## **1 BACKGROUND**

This report has been prepared in response to submissions received following public exhibition of the proposal. The public exhibition period ended on 13 July 2015.

## **3 SUMMARY OF MATTERS RAISED AND RESPONSE**

Figure 2: Original Proposal includes ANMM walkway (4m wide)

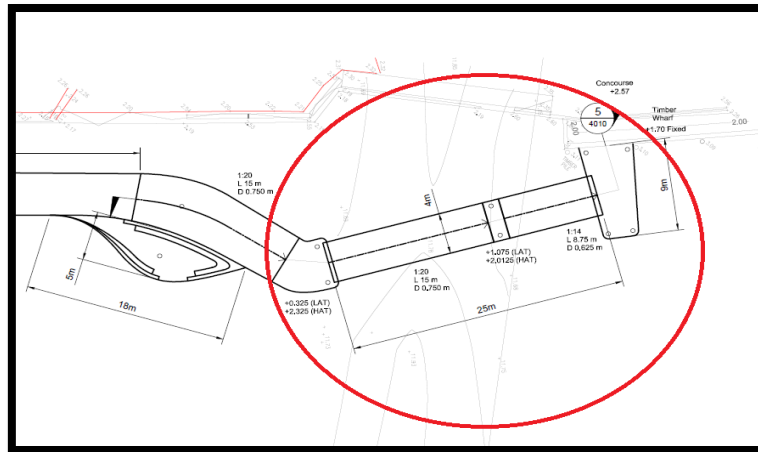
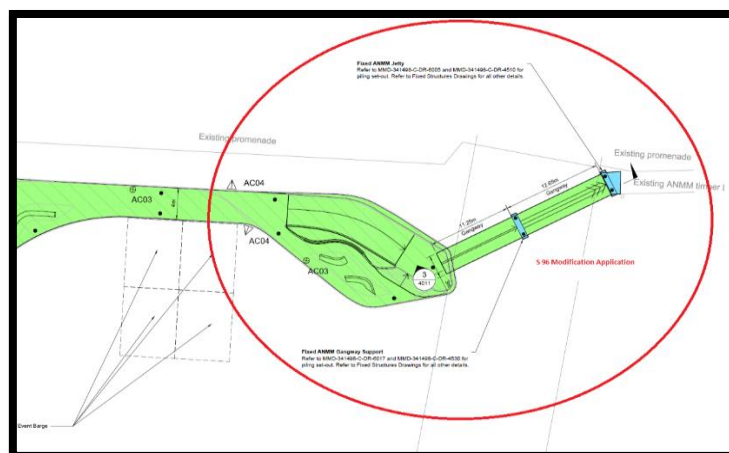
**Connecting ramp to the Australian National Maritime Museum (ANMM) site.** The ANMM has objected to the proposed northern connection of the western scheme into its water lease. This matter has been discussed with ANMM and the design has been amended to delete the connection. Refer Attachment B.

Roads and Maritime Services	No specific matters to raise in respect of the proposal	Noted
Foreshores and Waterways Planning and Development Advisory Committee	The Committee does not feel it necessary to provide any specific comments concerning this proposal	Noted
Australian National Maritime Museum	The ANMM does not agree to the intrusion and effective alienation of a section of the ANMM's water lease	The connection to the ANMM has been removed – refer revised plan at <a href="#">Attachment C</a> . The design is future-proofed to enable a connection to ANMM in the future if required.

The proposal has been amended to address the Australian National Maritime Museum's submission.
